Subject: RE: Planning procedures and St Pauls depot proposal (application ref: 2019/94099)

Proposed First Floor Plan

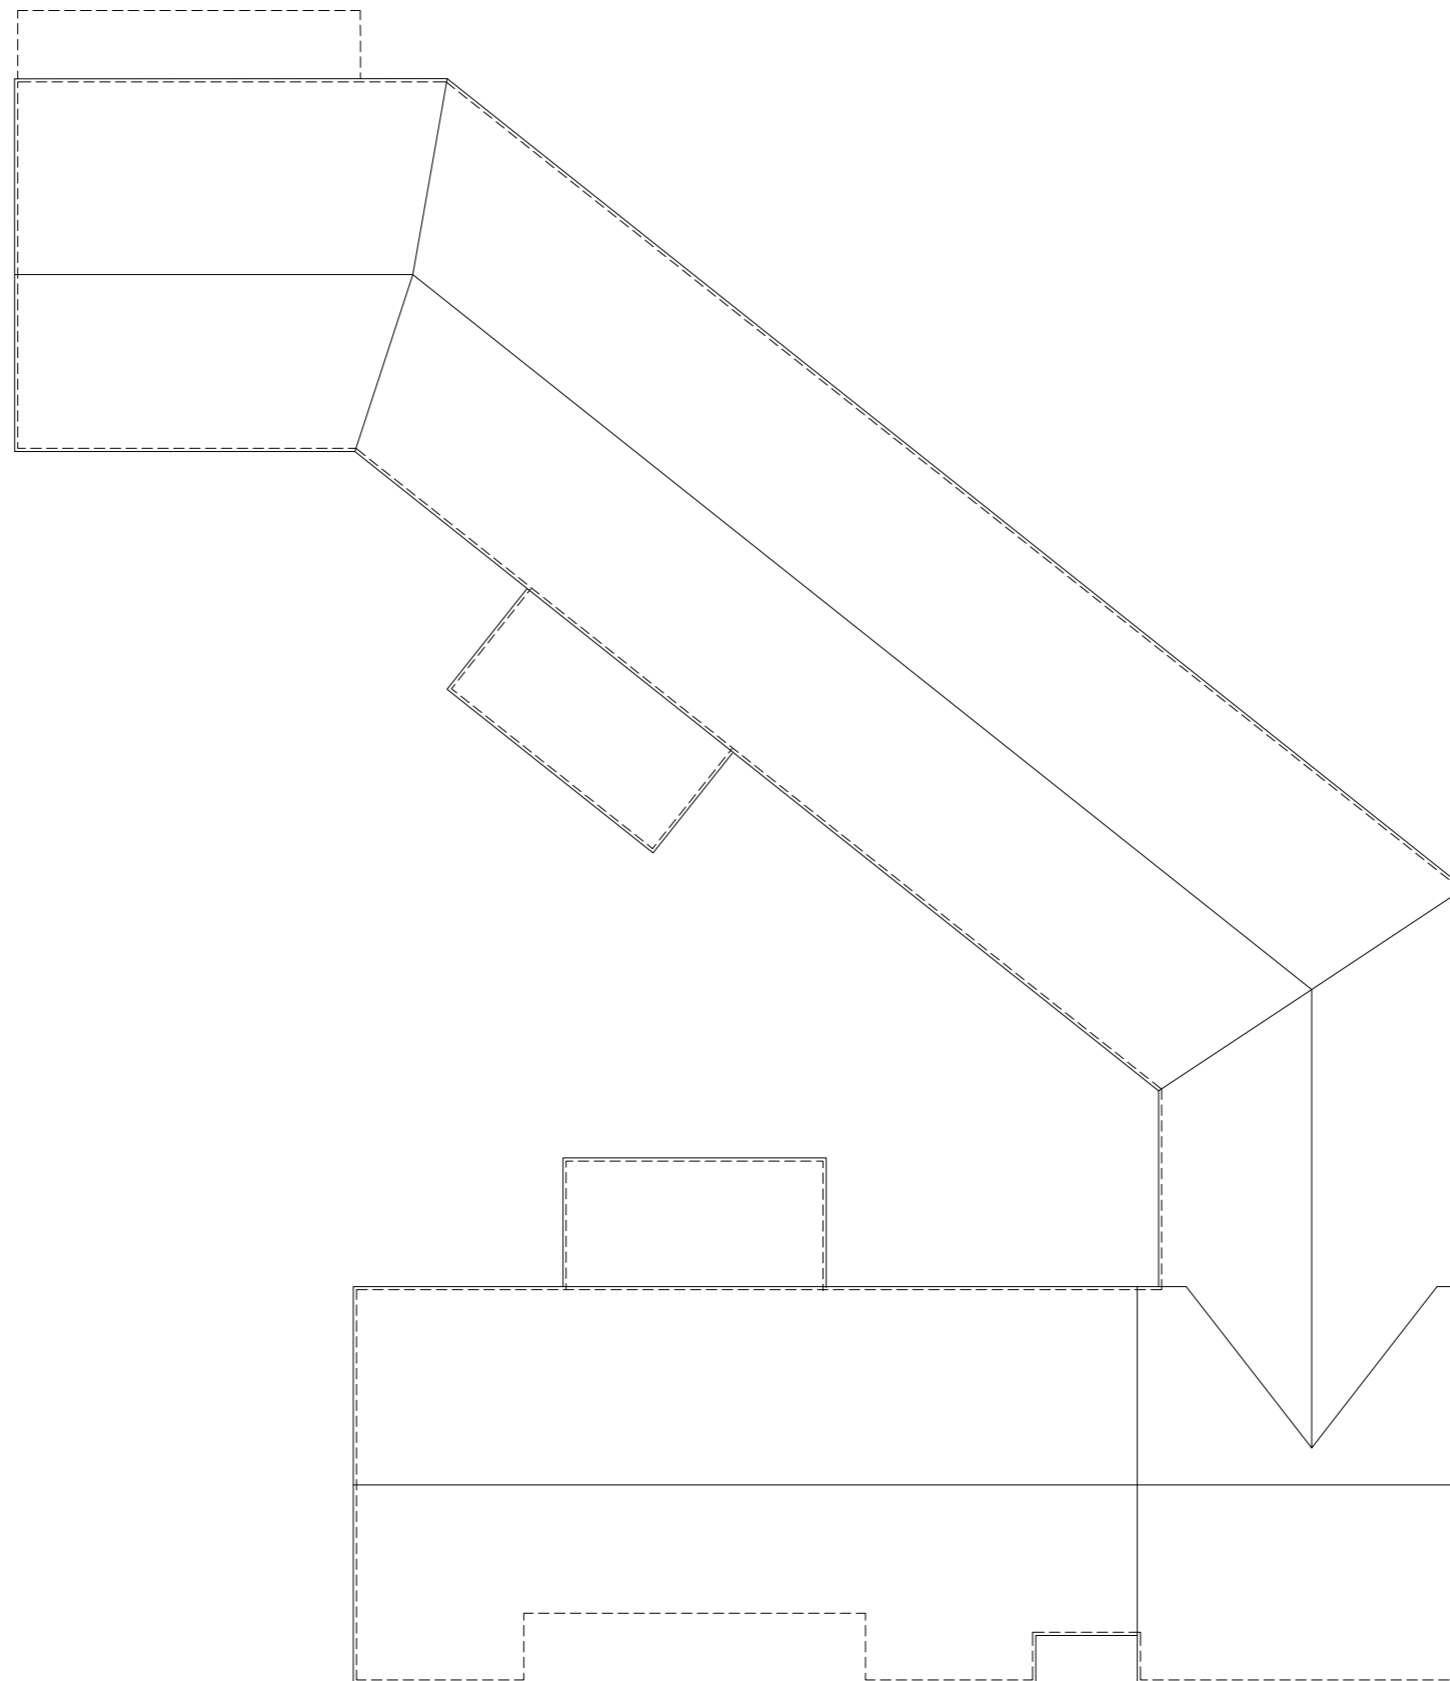
For what it is worth I think that overall the architects have done a decent job in terms of layout, design and trying to integrate the development into its surroundings. I feel for my neighbours who live opposite the development at 10, 12 and 14 St Pauls Road who will suffer a loss of privacy by being overlooked from living rooms and balconies at first floor level only a short

distance away. The occupants of the first floor flats will be looking straight across into their bedrooms and also down into their front living rooms. On a gloomy autumnal or winter day, with the lights on, it will be like living in a goldfish bowl. I do not see why those flats fronting on to St Pauls Road cannot be turned round so they have balconies facing into the internal courtyard. Has this been considered?

Proposed Front Elevation

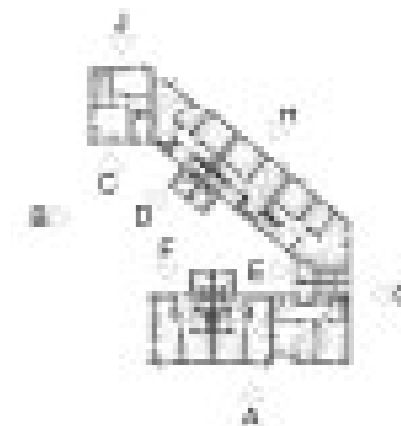
I am also concerned that balconies on the St Pauls Road elevation would be more suited to being on the front at a seaside resort and do not reflect the traditional character of St Pauls Road.
